**WELWYN HATFIELD BOROUGH COUNCIL  
EXECUTIVE DIRECTOR - PLANNING, PUBLIC PROTECTION AND GOVERNANCE**

**DELEGATED APPLICATION**

**Application No:** 6/2021/3107/HOUSE  
**Location:** 2 Densley Close Welwyn Garden City AL8 7JX  
**Proposal:** Erection of 1 x carport involving demolition of existing carport  
**Officer:** Ms Elizabeth Mugova

**Recommendation:** Granted

EXISTING CARPORT ELEVATIONS

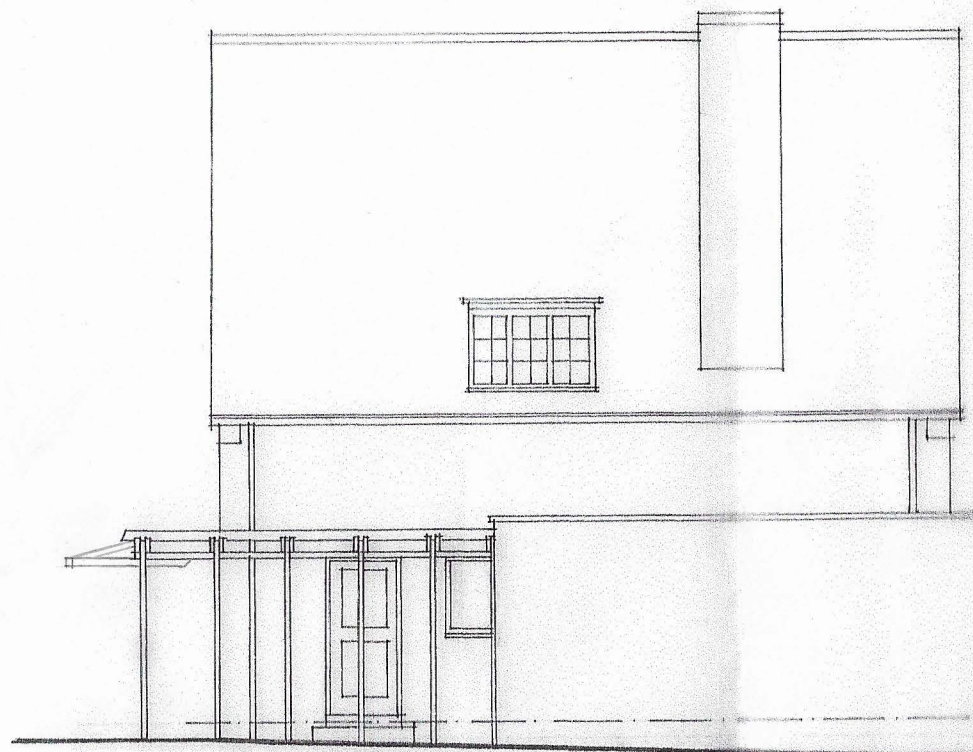
The Conservation Officer has been consulted on this application and confirmed no objection to the demolition of the current carport, which is a modern addition and is itself harmful to the Conservation Area. The Conservation Officer acknowledged that the proposed car port is less harmful than the current, but considered that it would still be harmful as it would not be in keeping with the character of the property or the Conservation Area. They concluded that the proposed replacement carport would cause the lowest end of 'less than substantial harm' to the significance of the Conservation Area.

PROPOSED CARPORT ELEVATIONS

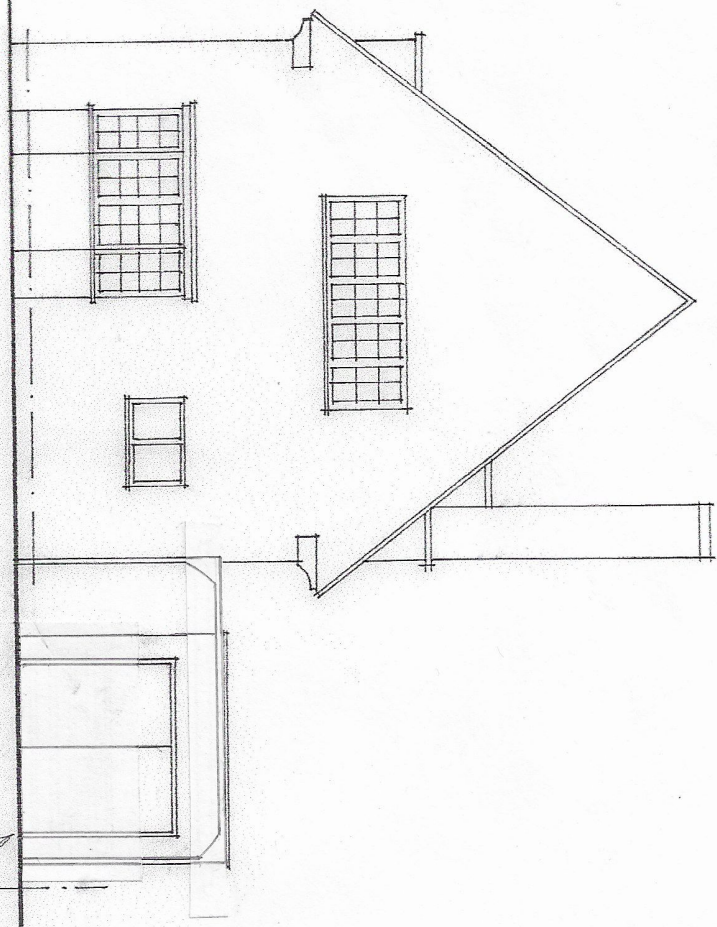
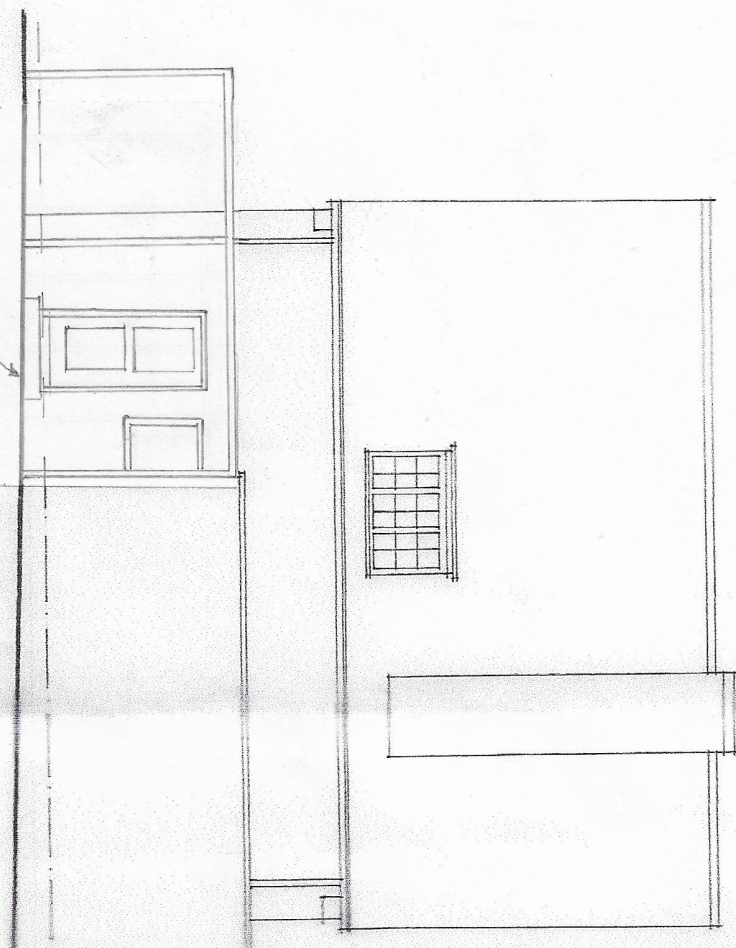
The agent has confirmed that the carport would feature a shallow mono-pitched roof behind a level fascia. The structure would be lightweight and more streamlined compared to the existing and would be finished in white aluminium to match the white side gate, garage doors and windows of the application property. Whilst the carport would project forward of the host dwelling, it would be to a similar extent as the existing carport.

Whilst the concerns of the Conservation Officer are acknowledged, on the basis that the proposed carport would be less harmful than the existing carport, the Local Planning Authority would not be justified in refusing planning permission.

1. The carport hereby permitted must be white in colour to match the side gate, windows and garage doors of the application property.
